Your ref:
Our ref: 21/00541/LDP
Please ask for: Mrs Lesley Raby
Direct dial: 01553 616818
Direct fax: 01553 616652
E-mail: borough.planning@west-norfolk.gov.uk

Details: **Lawful Development Certificate: Removal of conservatory, provision of new orangery extension and garage conversion to form bedroom at 12 Kestrel Close Burnham Market King's Lynn Norfolk PE31 8EF**

LOCATION PLAN SCALE 1:1250

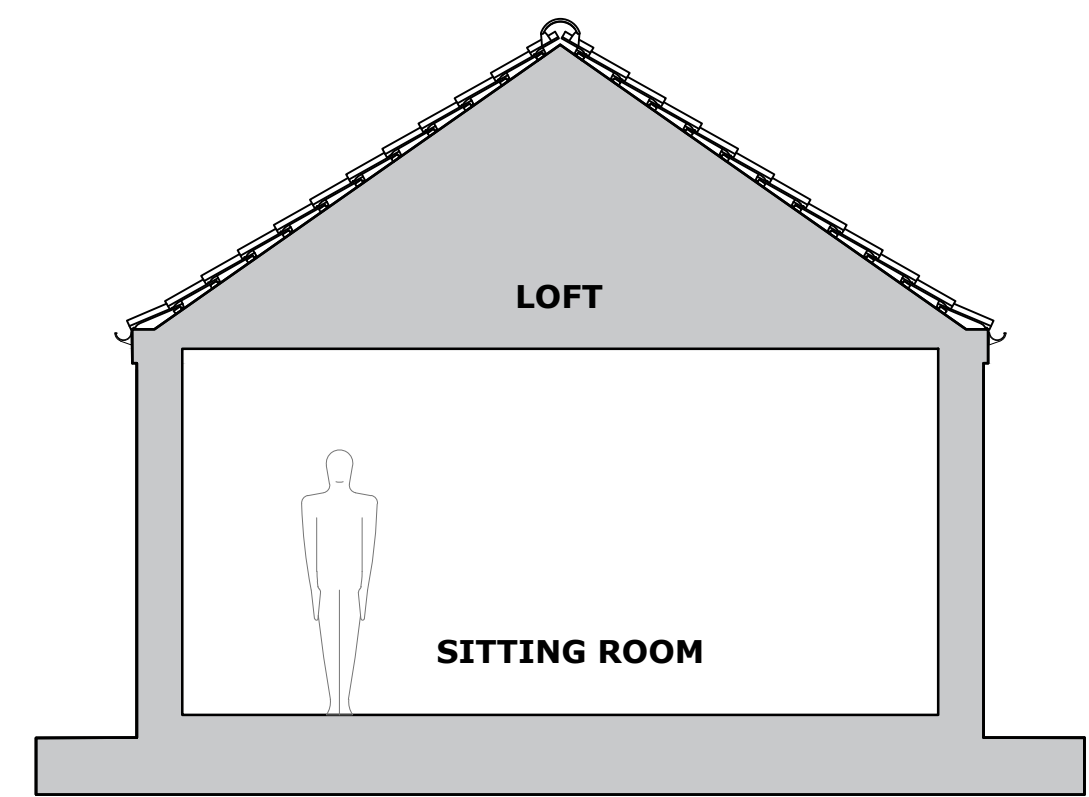
1. Outline the application site in red on the location plan around the residential boundary.
2. The site address and the map appear to refer to 12 Kestrel Close but the applicant address is at 10 Kestrel Close is this correct.
3. The proposed plan shows double doors to the east on the floor plan which are not shown on the elevation.
